Application for a non-material amendment following a grant of planning permission. Town and Country Planning Act 1990

Single storey rear extension, first floor side extension & 2 No. roof lights within loft space

Reference number: R/101/15/HH

Reduction in floor level of rear extension by 300mm, with parapet height remaining as approved.

Drawing Title
Existing and Proposed
Floor Plans and Elevations

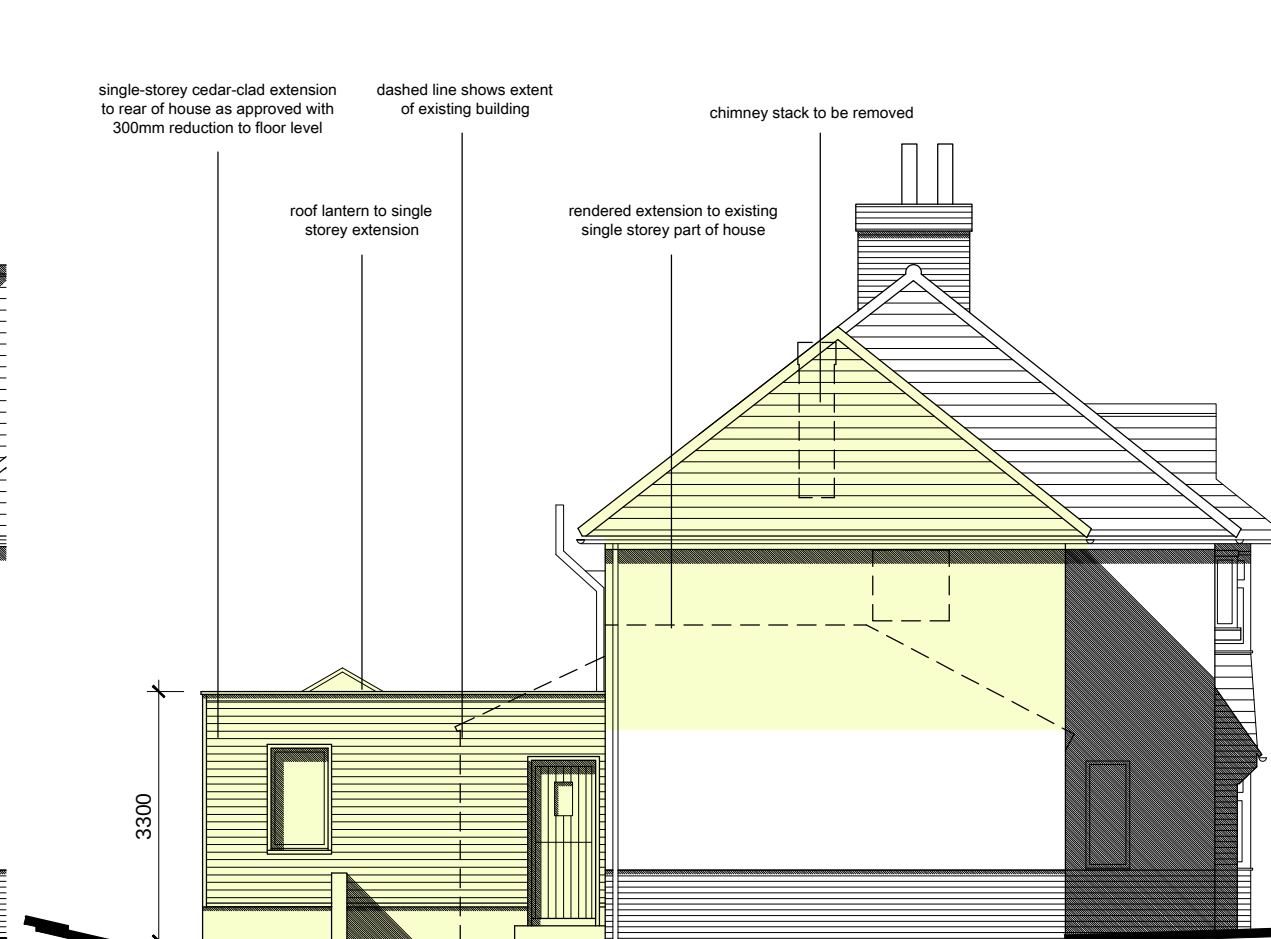
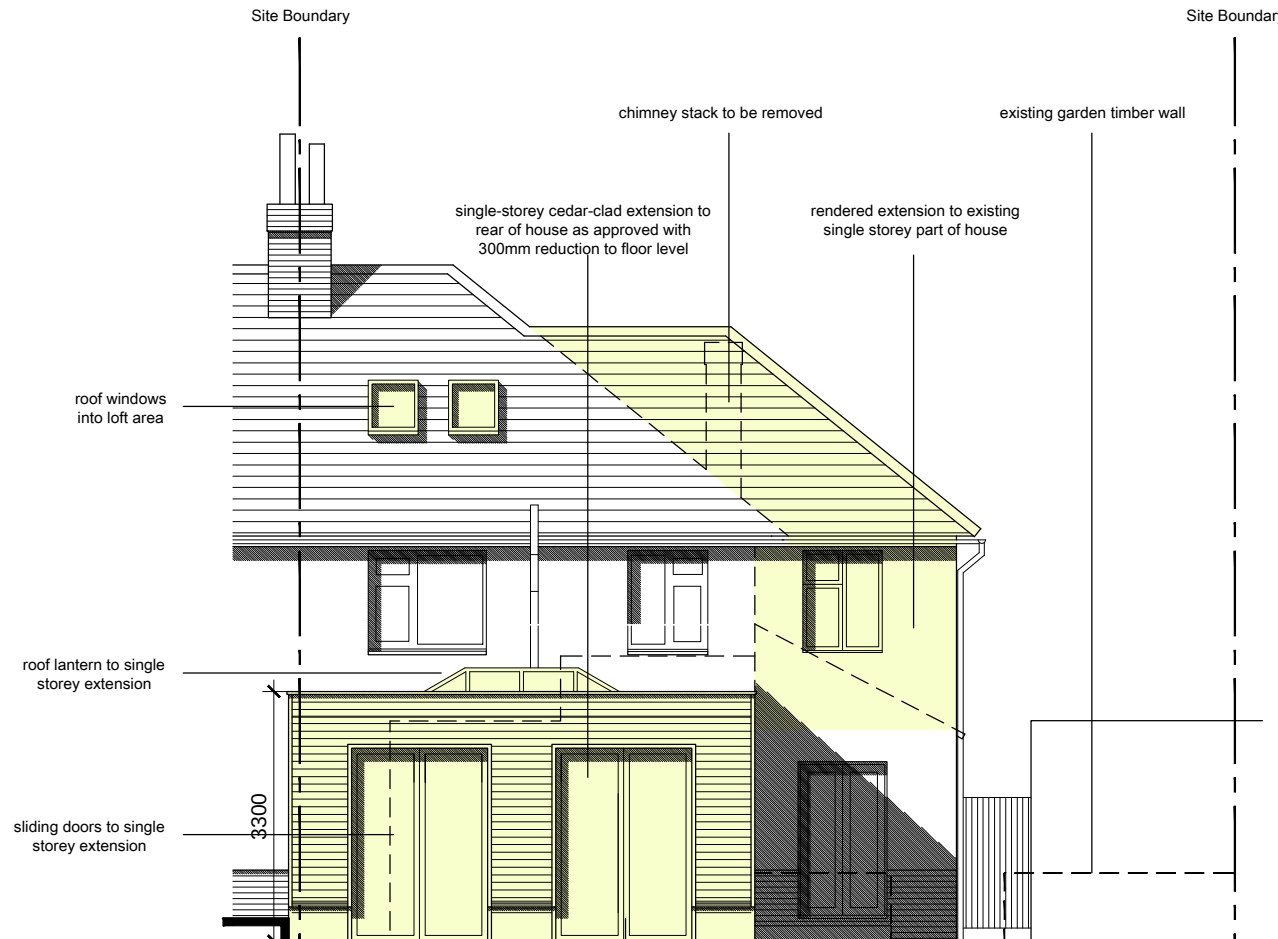
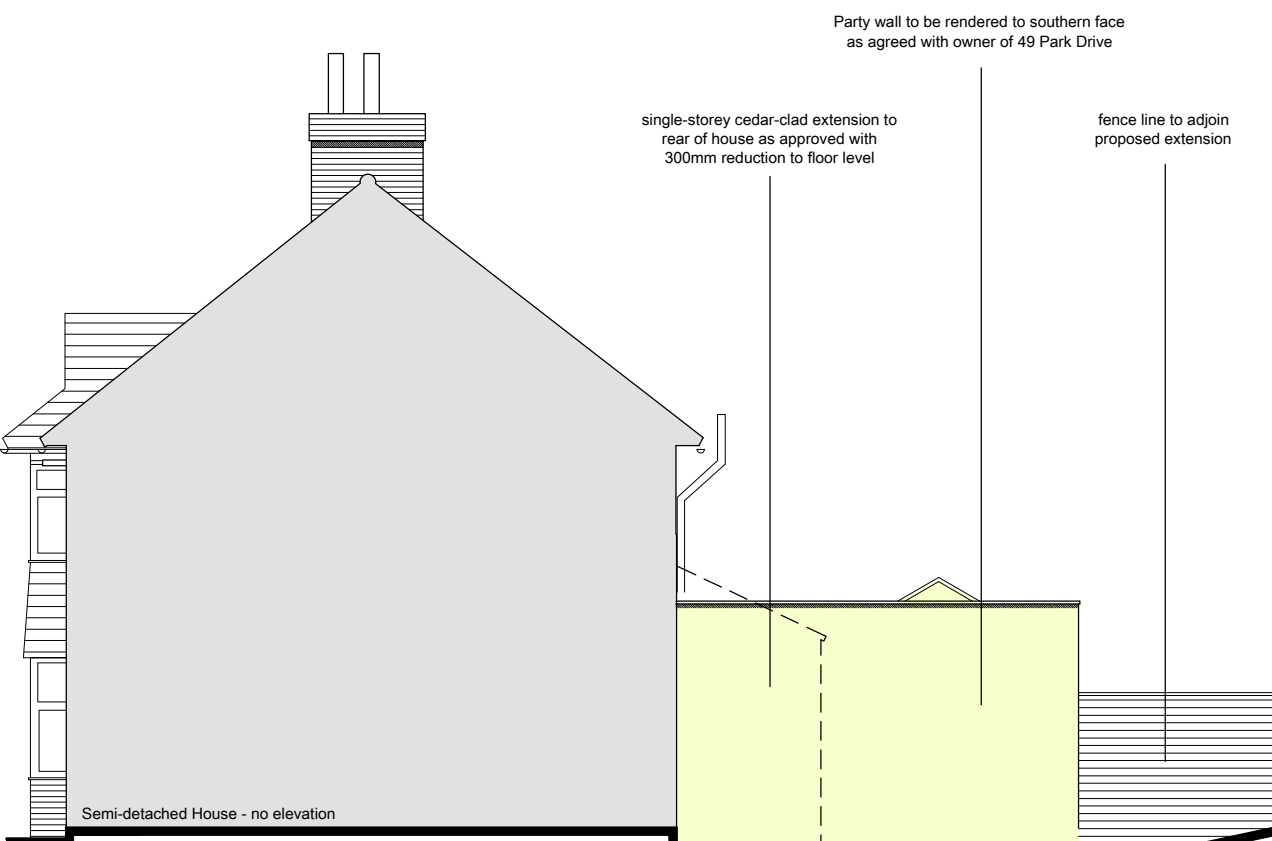
As there is no increase in height to the extension, there are no effects to any surrounding property and therefore no reason for the proposed amendment to be resisted.

Drawing Title
Site Location and Block Plan
& Indicative Section

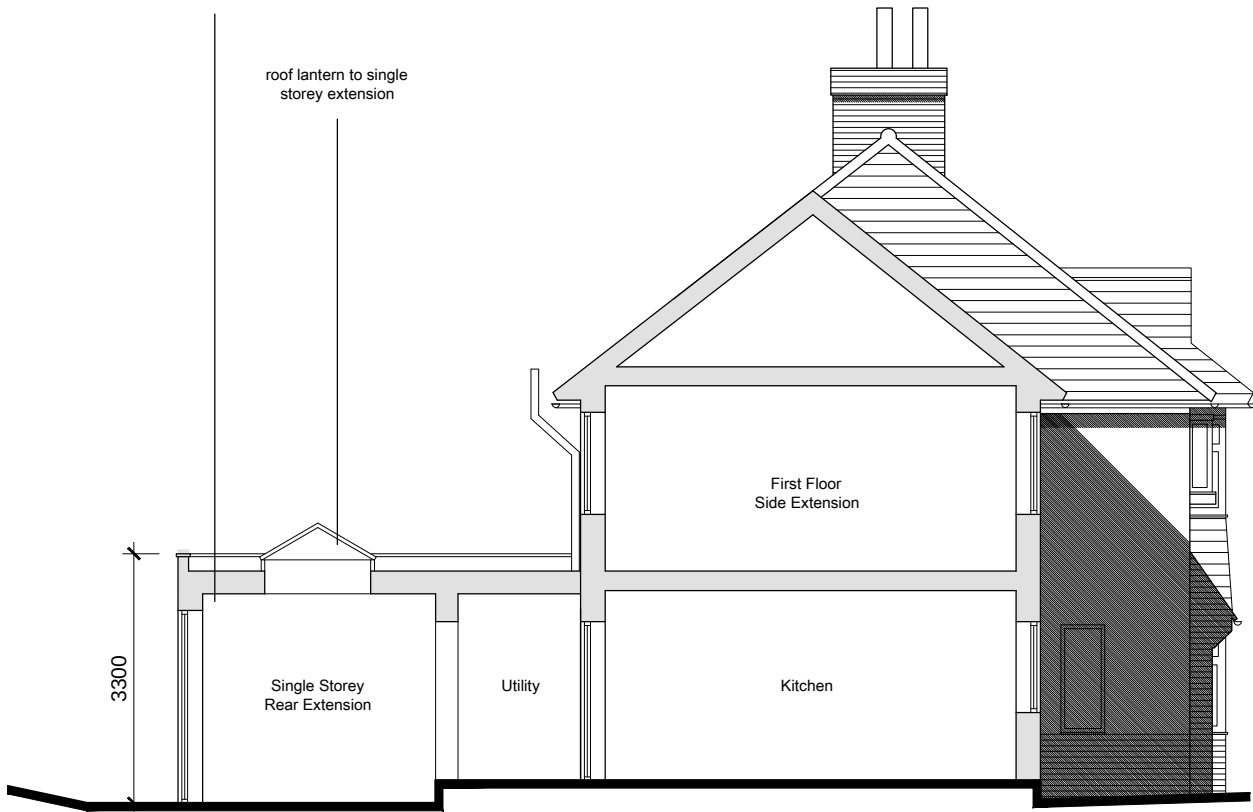
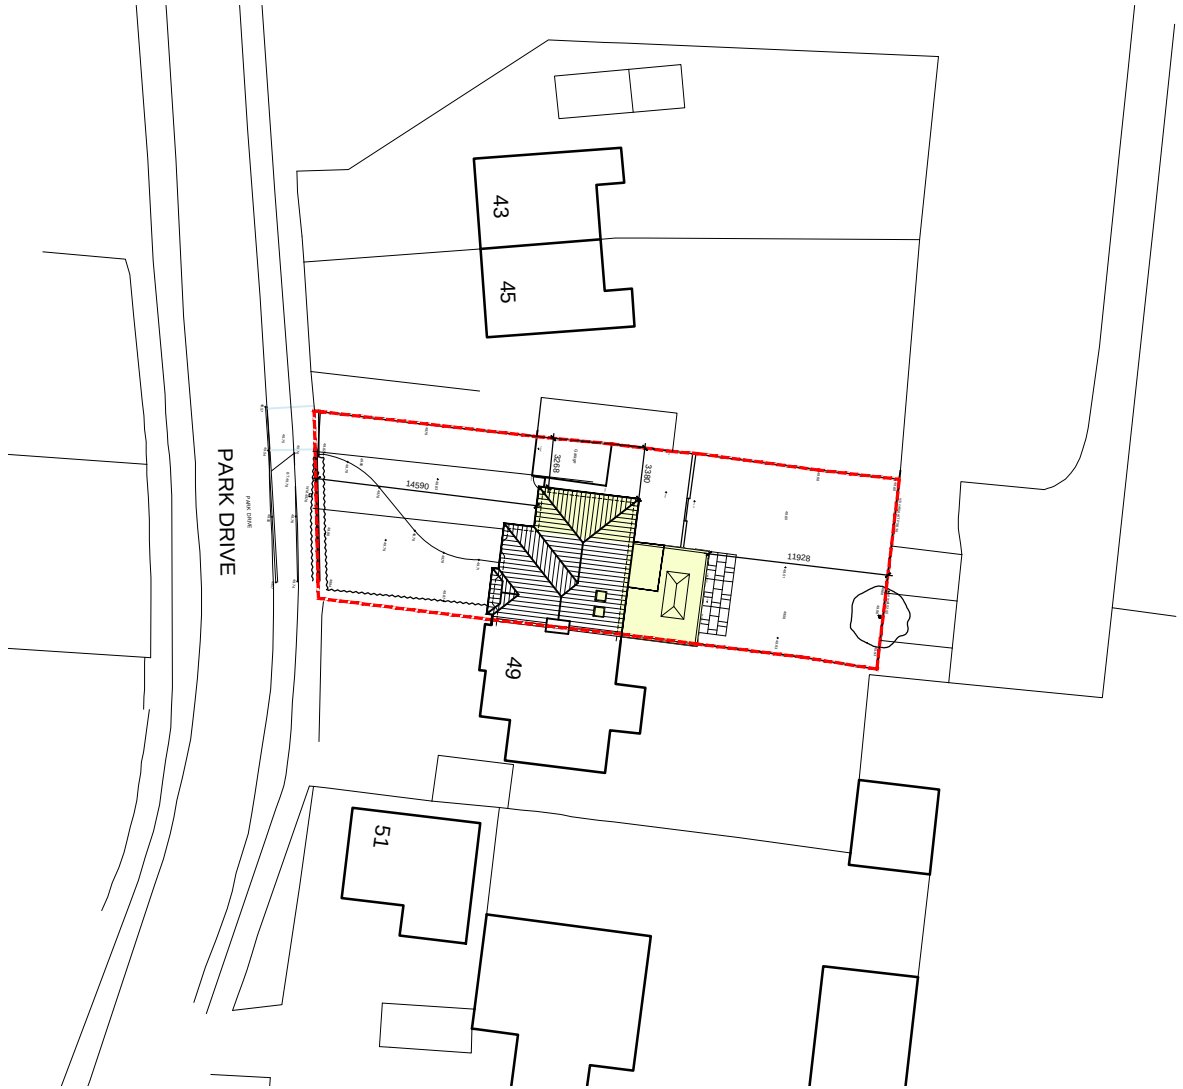
To reduce the floor level in the proposed extension. This amendment will not be visible by anyone except the property owner.
